**From:** [Berry, Jon](#)  
**To:** [Norfolk Boreas](#)  
**Subject:** Norfolk Boreas Wind Farm Project - Breckland Council  
**Date:** 09 December 2019 11:25:16  
**Attachments:** [Norfolk Boreas Breckland Council SoCG 04.12.2019.docx](#)  
[Norfolk Boreas Wind Farm - Local Impact Report Summary 04.12.2019.docx](#)  
[Norfolk Boreas DCO Application - Breckland Council Local Impact Report 04.12.2019.docx](#)  
[Norfolk Boreas Breckland Council Environmental Health Answers.docx](#)

Please see the attached Statement of Common Ground, the Local Impact Report and a Summary of the Local Impact Report for the Norfolk Boreas Wind Farm project. The Local Impact Report addresses the majority of the written questions put forward by the Examining Authority for Breckland Council, though I also attach a specific response from the Environmental Health team to matters relevant to those officers.

I have had a look at the questions posed and been back through the PEIR and answered anything that I think is pertinent to BDC

Royal HaskoningDHV
Enhancing Society Together

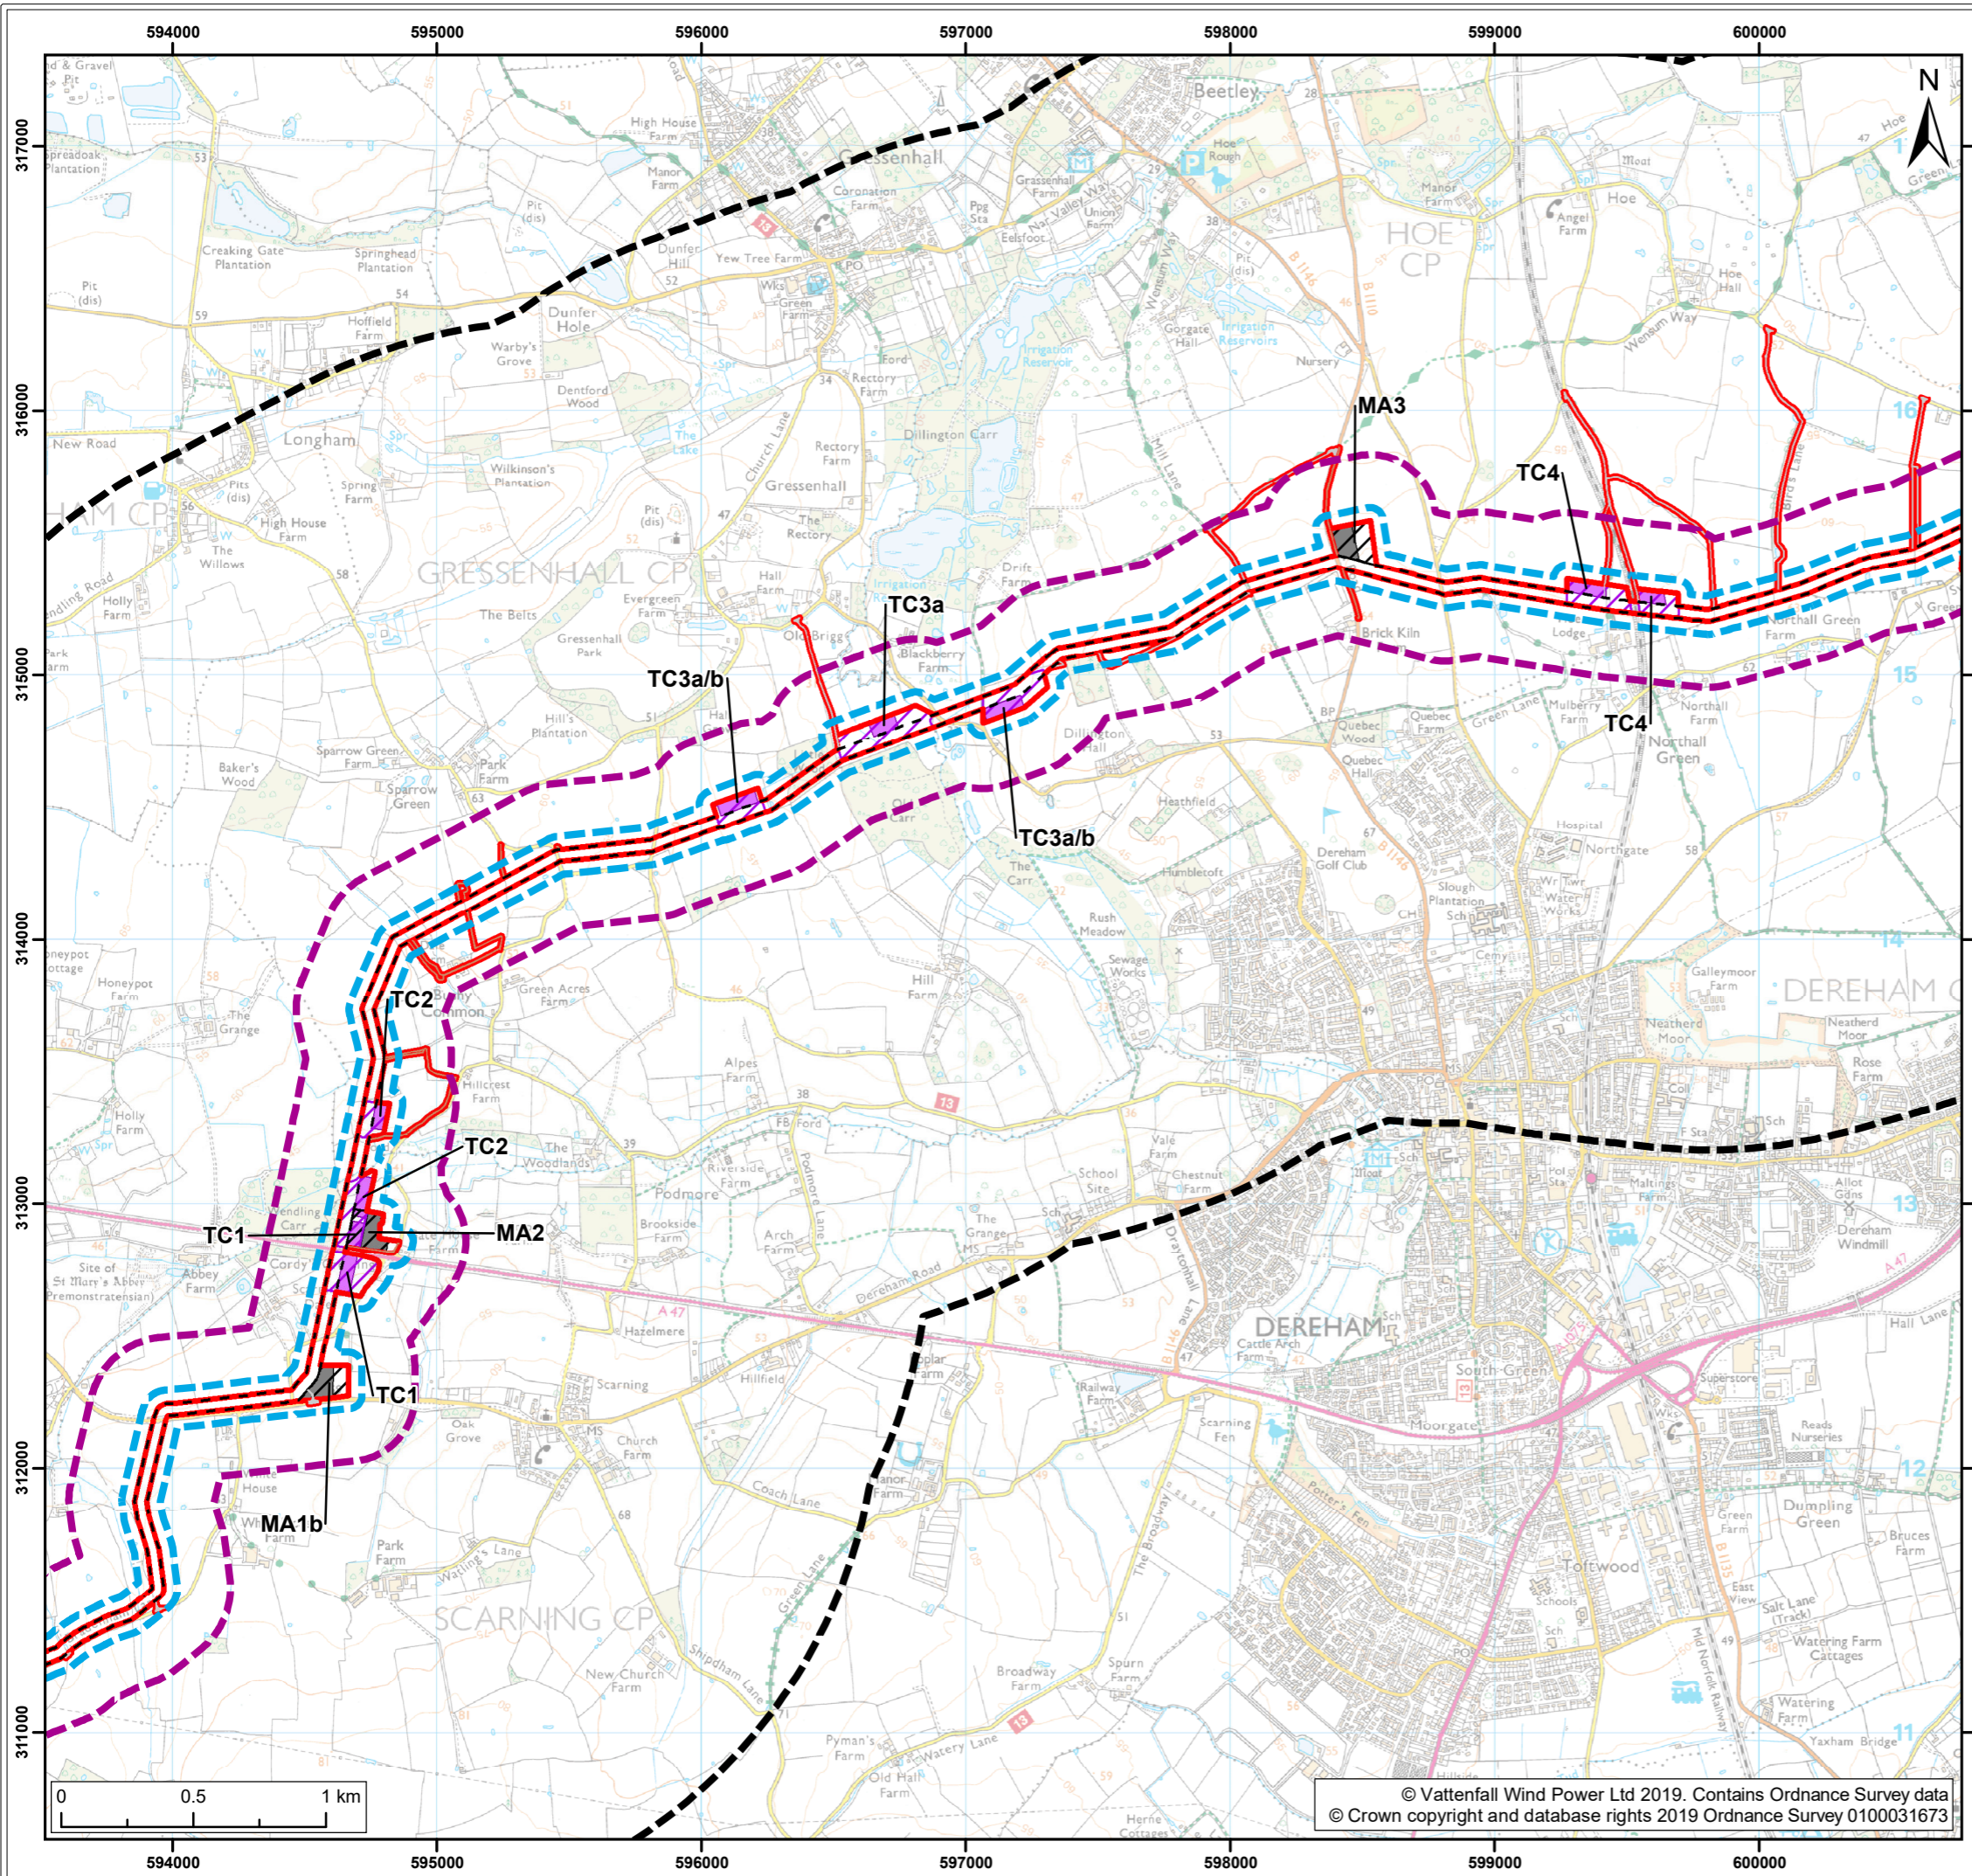
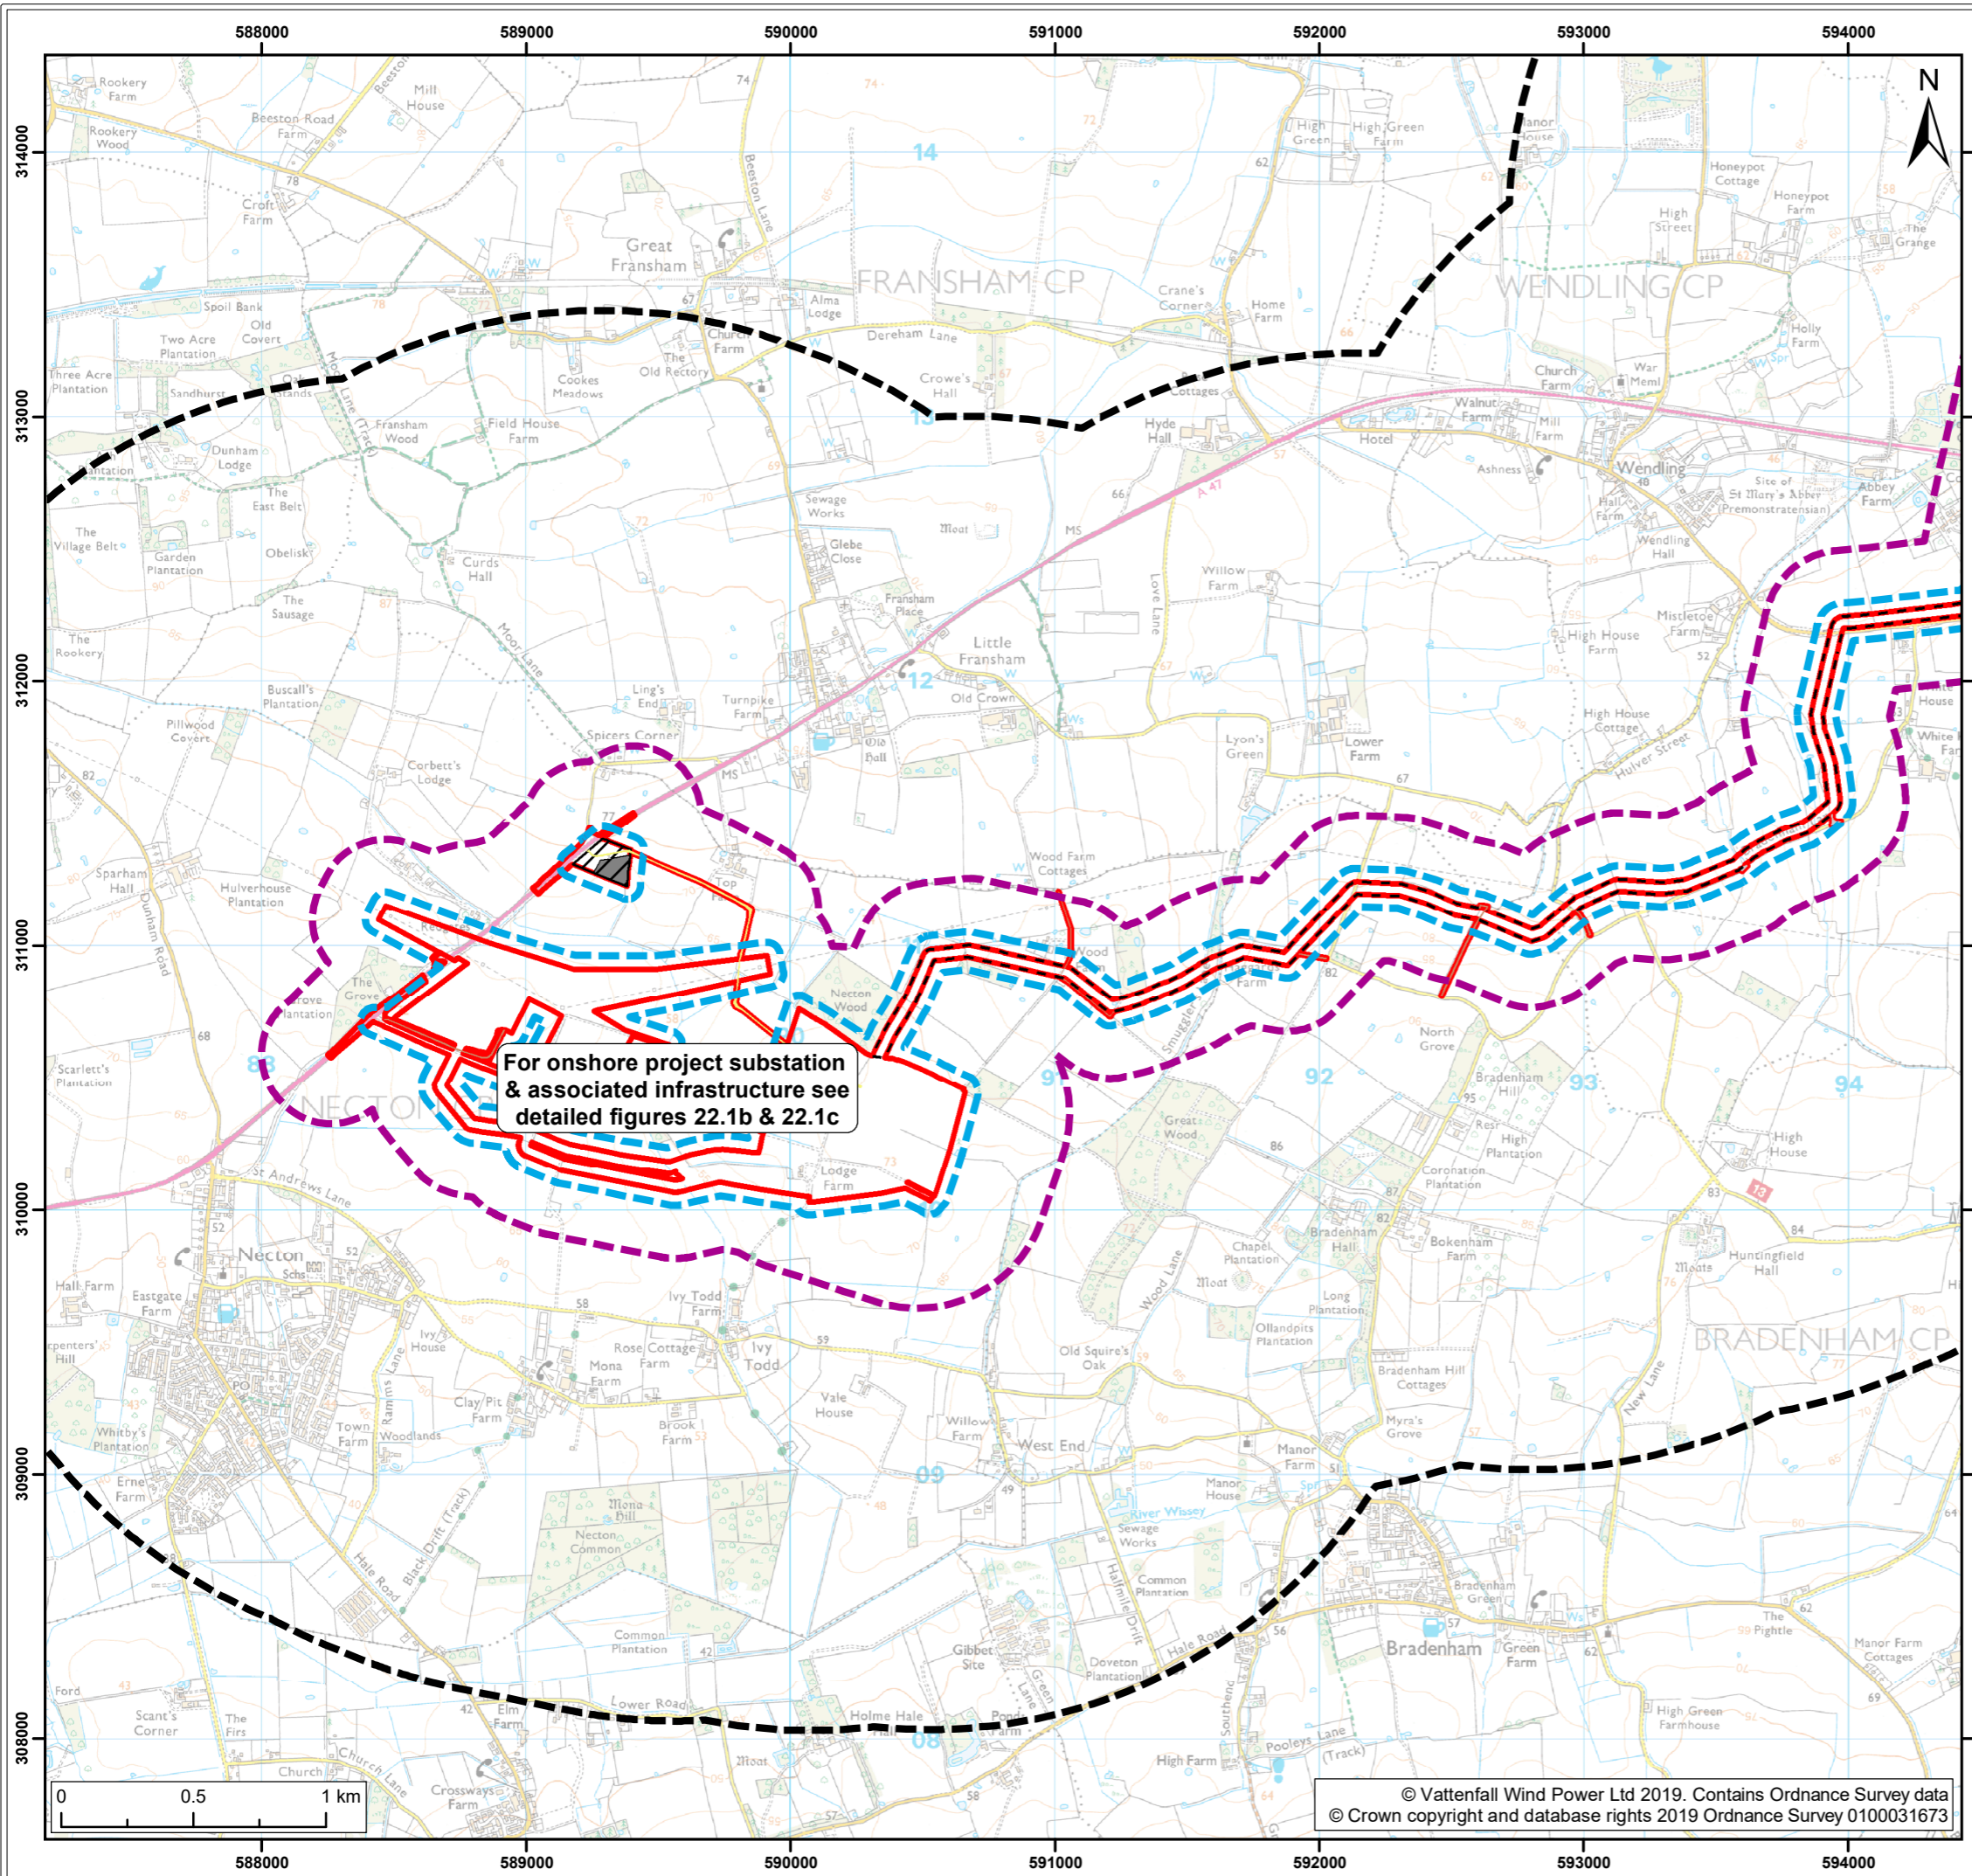
Part of map 6 and maps 7, 8 and 9 show Breckland district. For the cable route receptors CCR, there are 14, of which 6 are on the southern or south east side of the cable route. Having looked again I feel they are representative of the residential areas.
